**Re: Explora Science Center & Children's Museum Addition and Renovations,
1701 Mountain Road NW
Request for 30-day Temporary –Accepted
Engineer's Stamp dated: 6-18-12, (J13D070)
Certification dated: 8-28-13**

Based upon the information provided in the certification received 8-28-13, the above referenced certification is acceptable for a release of a 30-day Temporary Certificate of Occupancy (CO) by Hydrology.

DRAWING TITLE: DRAINAGE PLAN AND CALCULATIONS

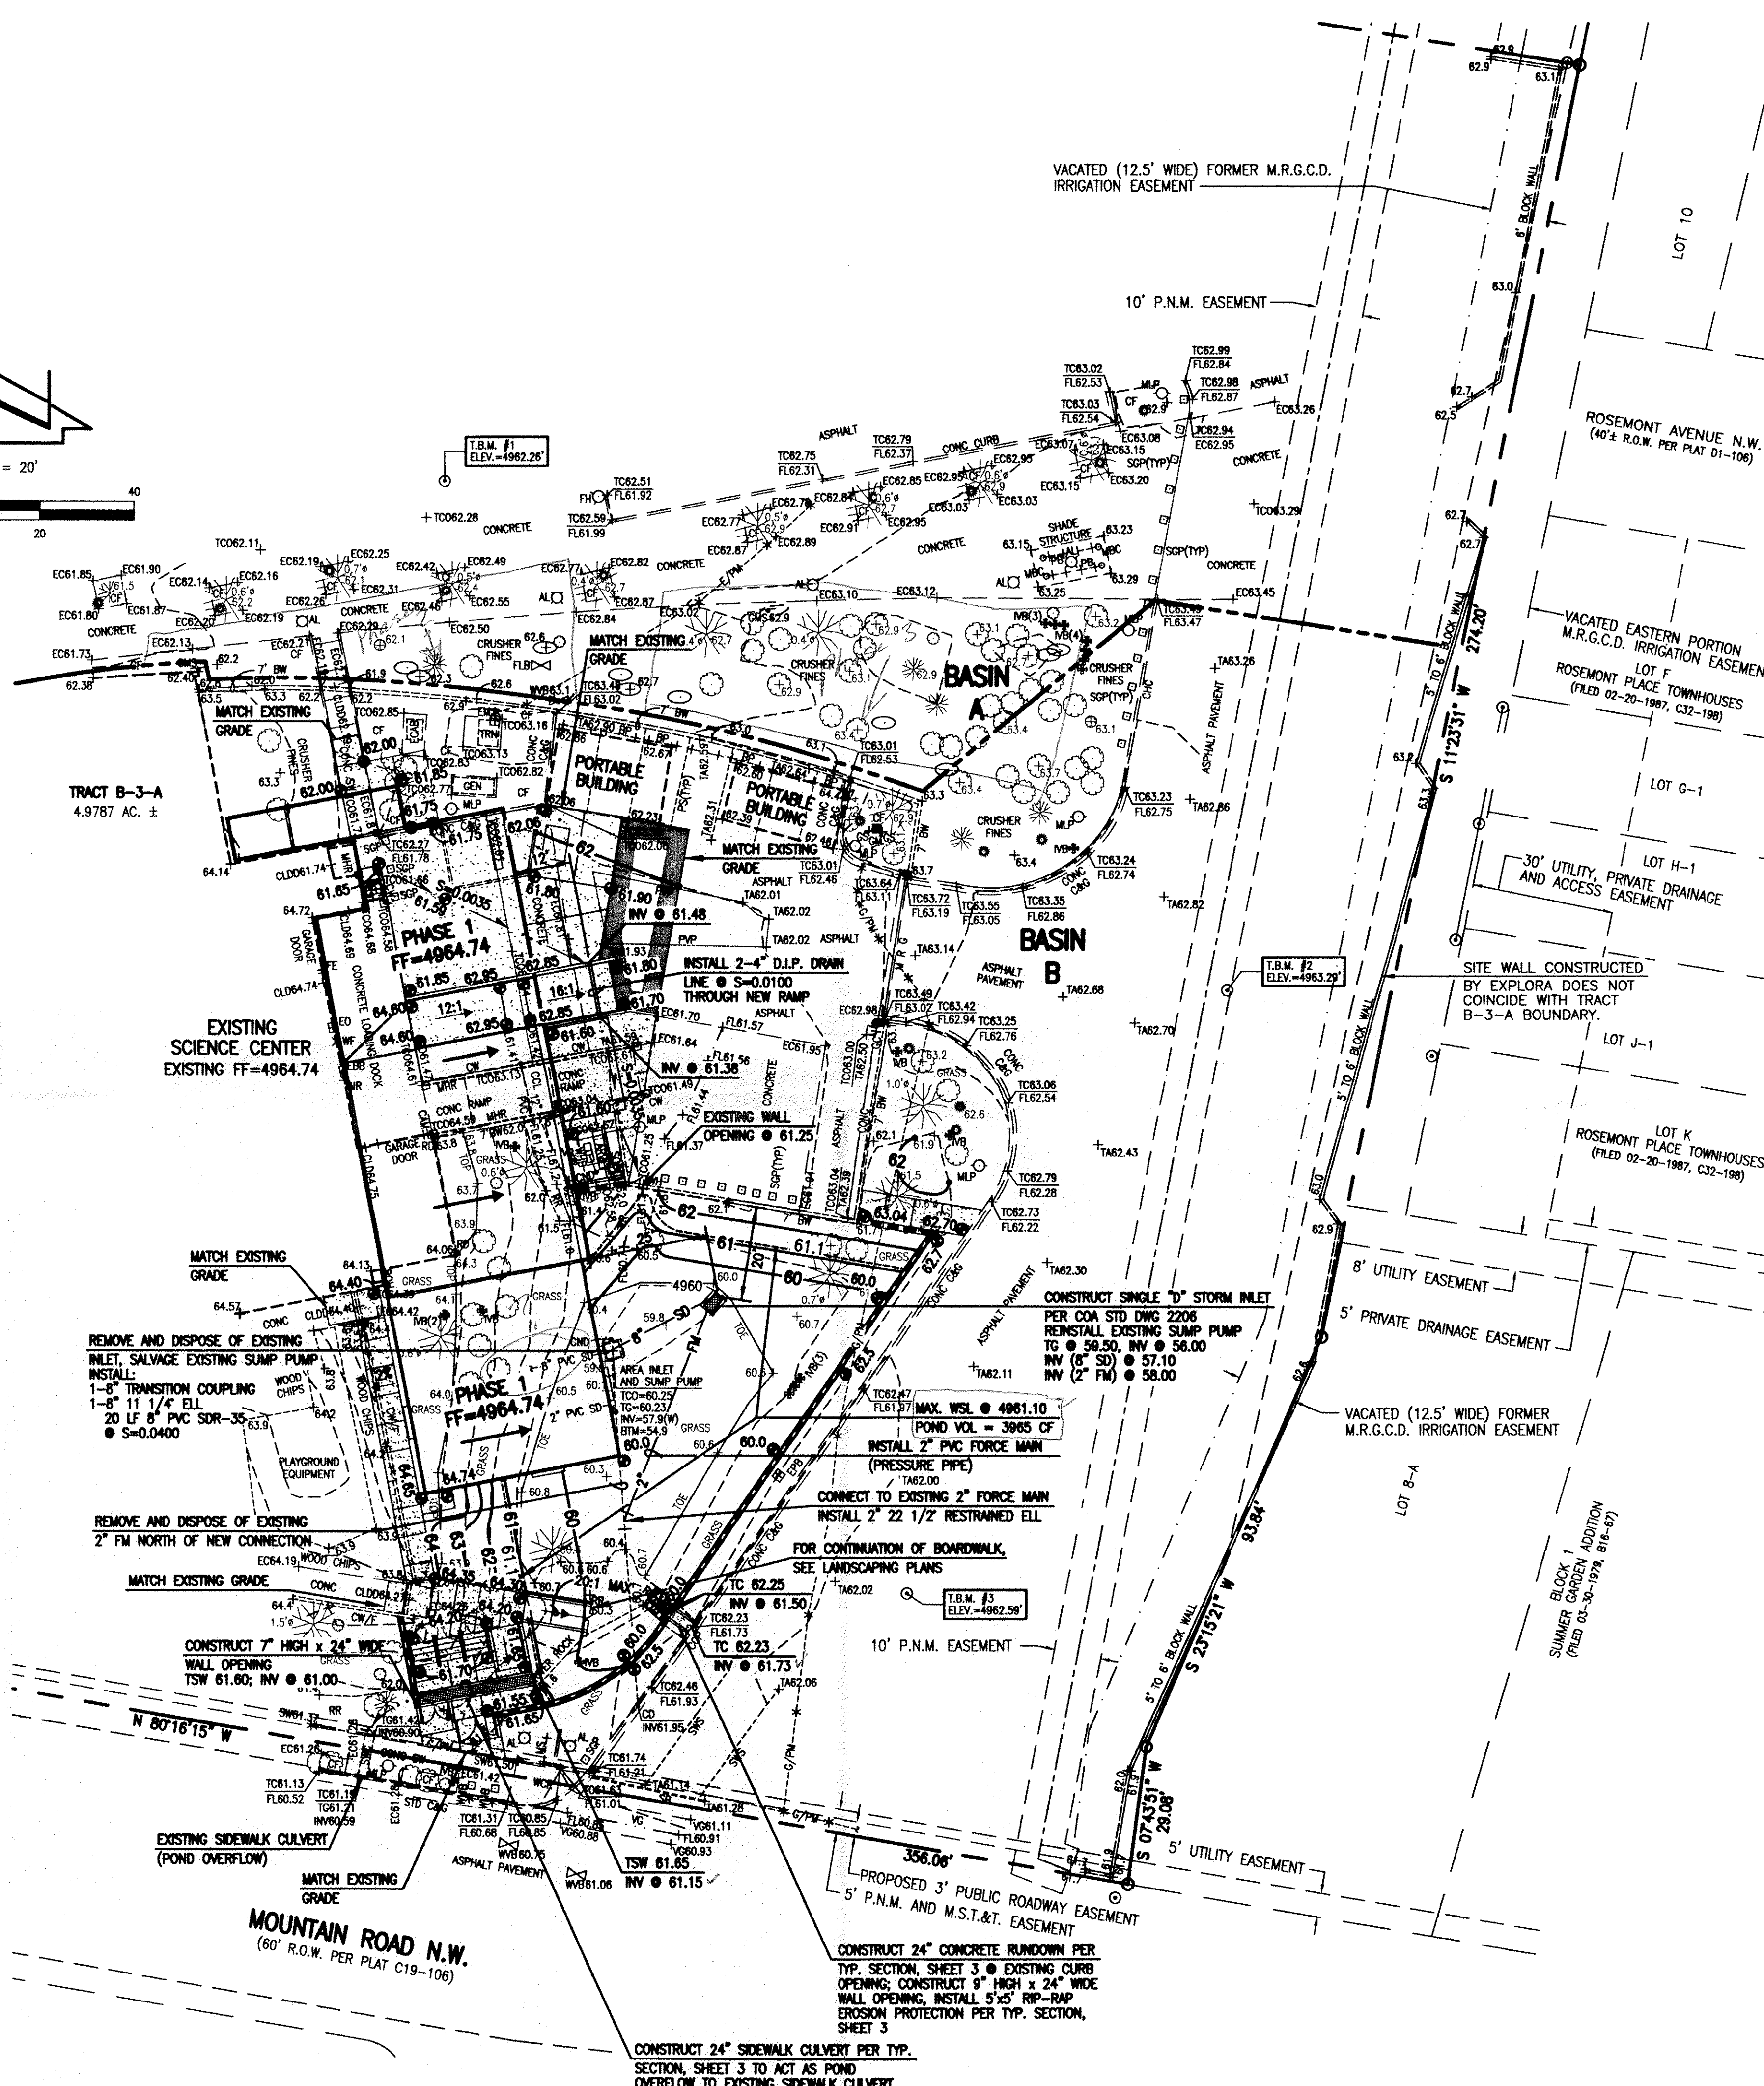
When submitting for Permanent CO in addition addressing the exceptions listed , please determine if the 2" force main has backflow prevention since the curb flow line elevation is higher than the pond bottom elevation.
